Subject: RE: Kings Beach - P/4/18/PL

Subject: Pre-Application Advice - Land adjacent to Former Kings Beach Hotel (now a Co-Op), The Parade, Pagham, PO21 4TW

Thank you for your request for Pre-application advice regarding the above site in relation to the installation of electric gates to both entrances to the development approved for three dwellings under ref: P/4/18/PL.

Drawn By	Date	Checked By	Date	Approved By	Date
KW	Dec 17				
Drawing No	17.3030.100	Revision	P2	Scale	1:200@A2

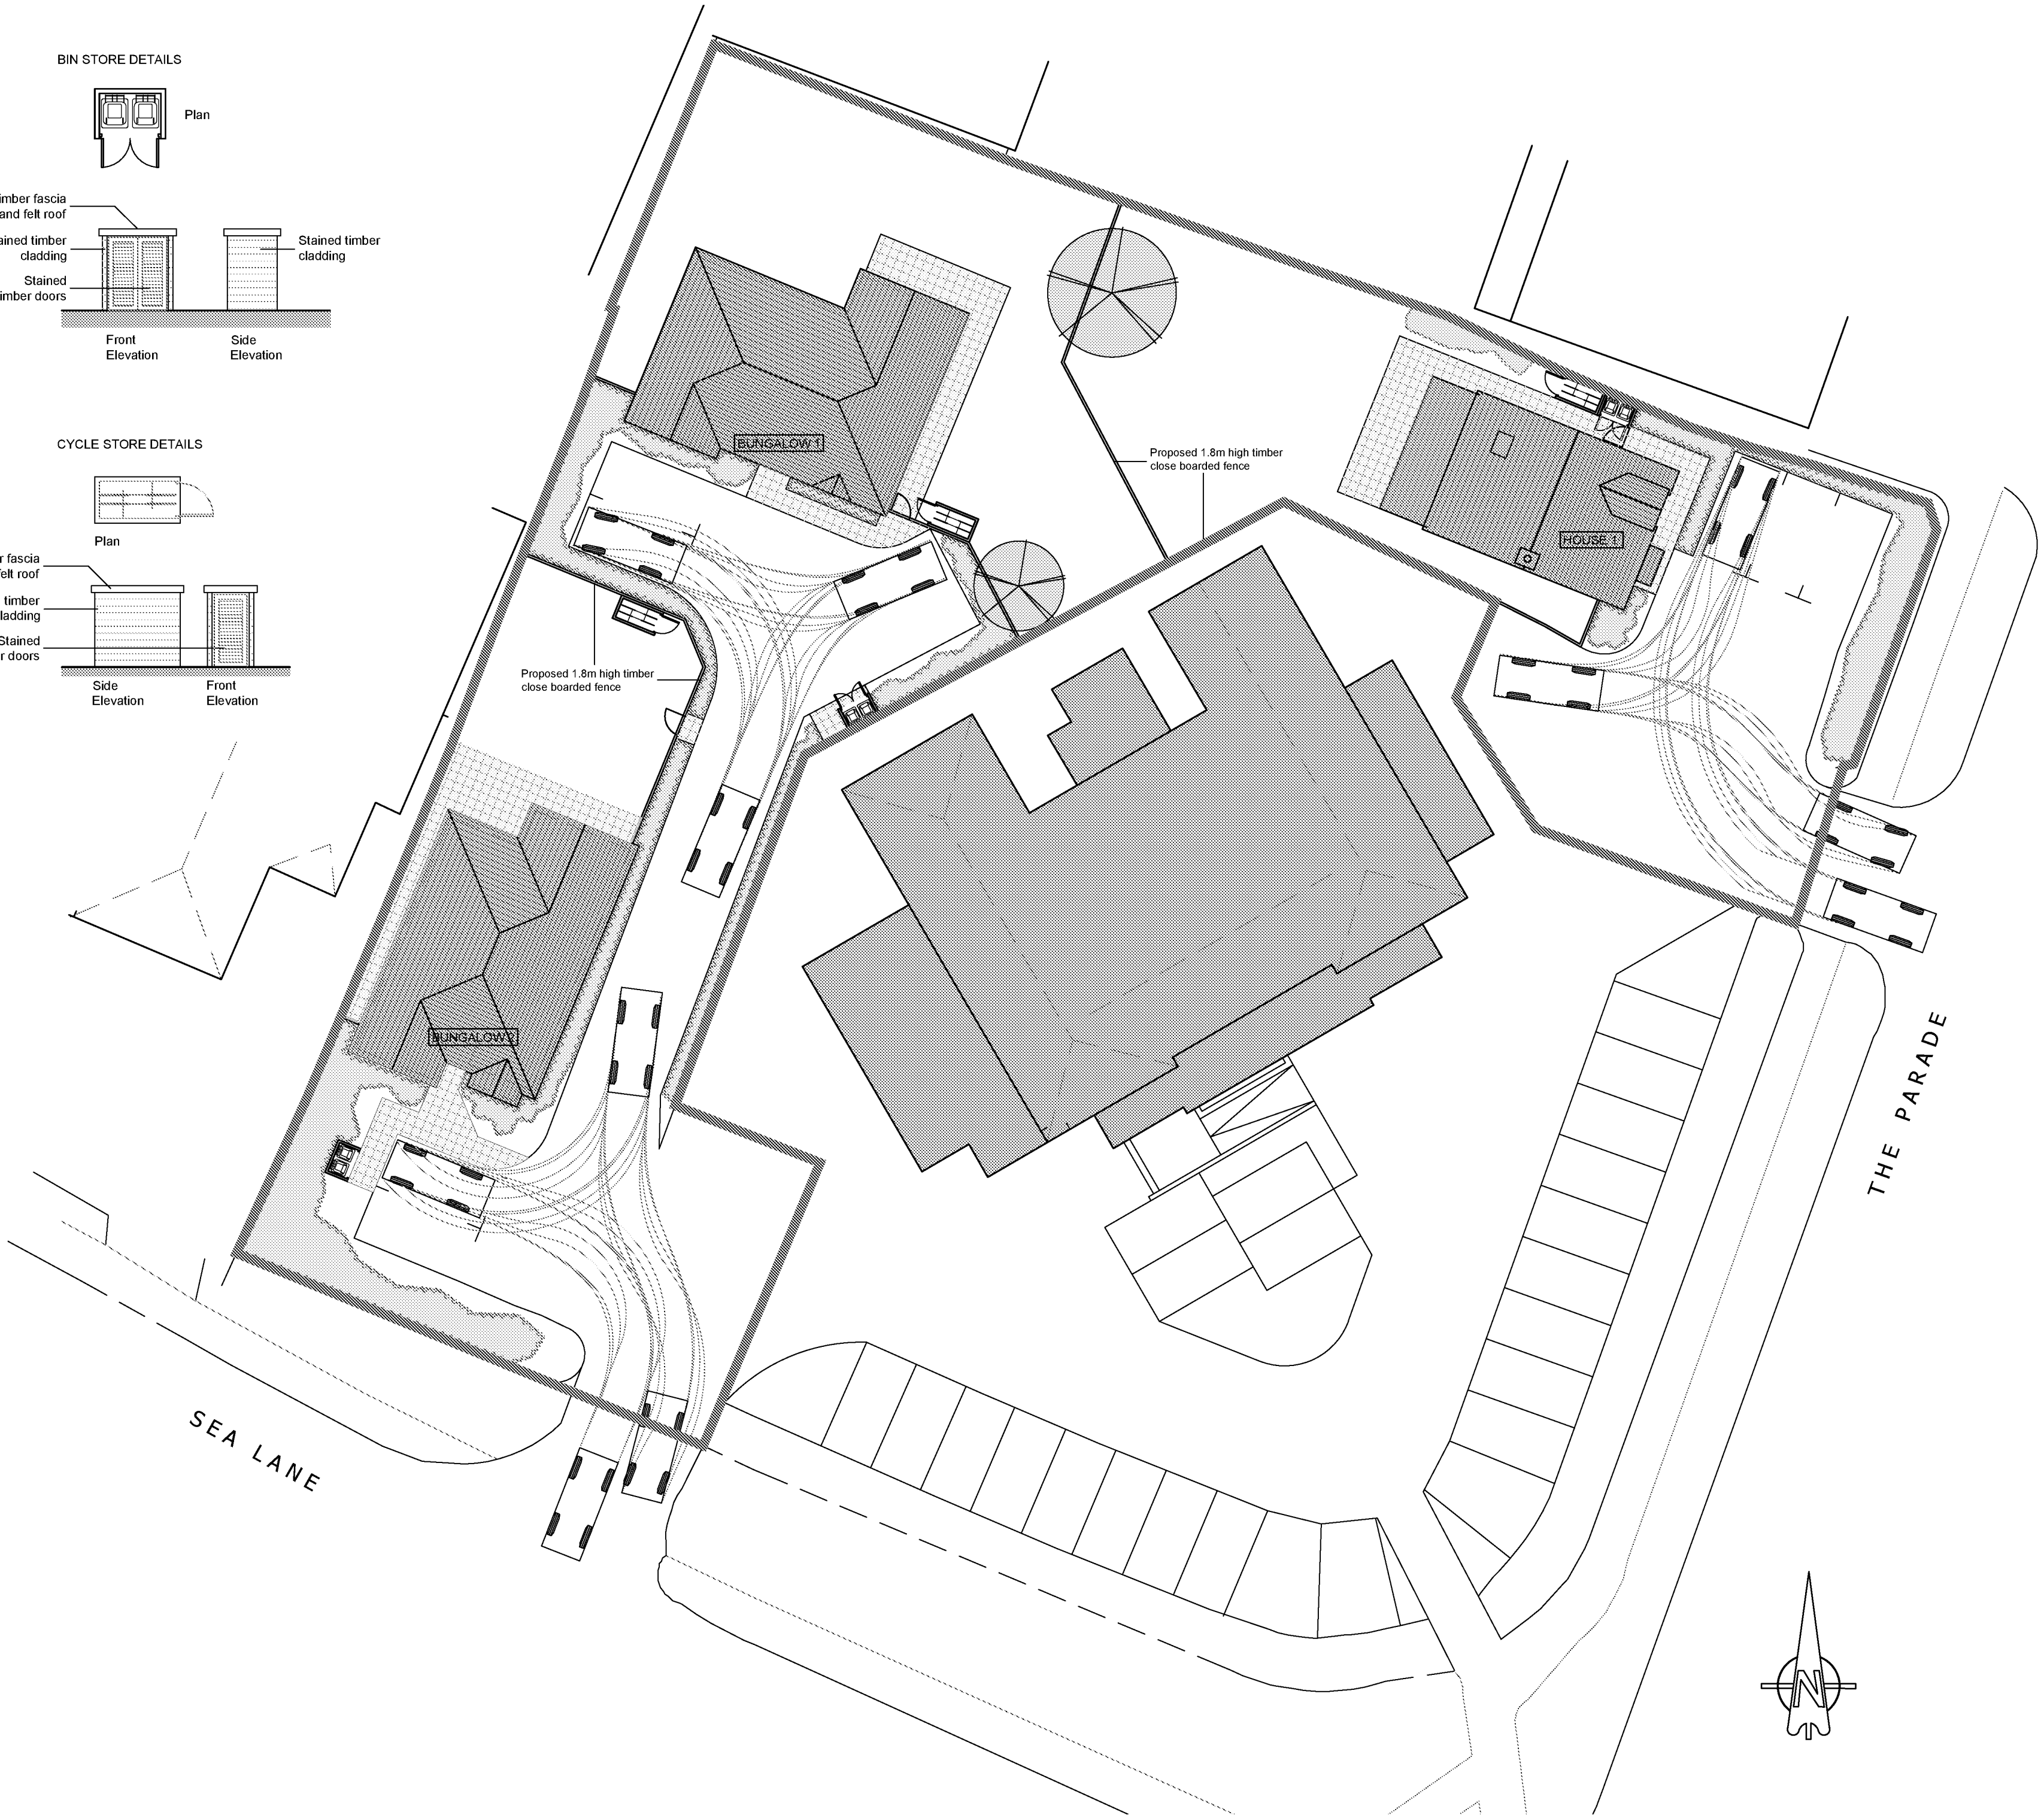
The proposed plans indicate that the gates will be 3.6m in width, situated within private land, and not within the public highway. Vehicles will have space to wait off of the highway whilst the gates are operated. At the full planning application stage, we would anticipate that further information relating to the proposed gates is provided – will these be sliding gates? How long will they take to open fully? If not, the gates should open inwards of the site to ensure that swing gates do not obstruct other vehicles entering or exiting the Co-Op. Whilst this would not strictly speaking create a highway safety concern, obstruction of the entrance or exit of vehicles from the Co-Op could result in vehicles having to wait on the highway to enter the site.

I note that swept path tracking has been provided demonstrating vehicles exiting each gated entrance in a forward gear. For the two dwellings to the west of the site, this would appear workable due to the ability for vehicles to turn on site within the gated area. There appears to be sufficient space for other vehicles to either wait whilst the gate to the west is operated for a vehicle entering the site or to pass the waiting vehicle. However, to the east of the site, no turn on site is available within the gated area. This means that vehicles will either be required to reverse into the site in order to exit in a forward gear, or to reverse out of the site and turn within the Co-op area to exit onto the public highway in a forward gear. This has the potential to result in other vehicles having to wait longer in order to pass and these reversing manoeuvres should be demonstrated as workable at the full planning stage, demonstrating that there is sufficient space for other vehicles to either wait or pass whilst the manoeuvre is undertaken. You may wish to consider widening the proposed gate at this entrance in order to improve manoeuvrability for vehicles.

In principle, subject to sufficient swept path tracking demonstrating the workability of the manoeuvres to the east of the site and the ability for other vehicles to wait/pass, I do not foresee this proposal resulting in a highway safety concern. I do not anticipate that there will be sufficient trips to and from the proposed dwellings to result in vehicles queuing on the public highway to gain access to the site.

We would have concerns visually with a fence/gate of that height and would suggest that it would need to be a lower fence say 1 or 1.2m to be acceptable. I also consider that this may have highway implications if vehicles have to wait for the gate to open thus blocking a Coop car park entrance/exit – and you may want to discuss this with WSCC.
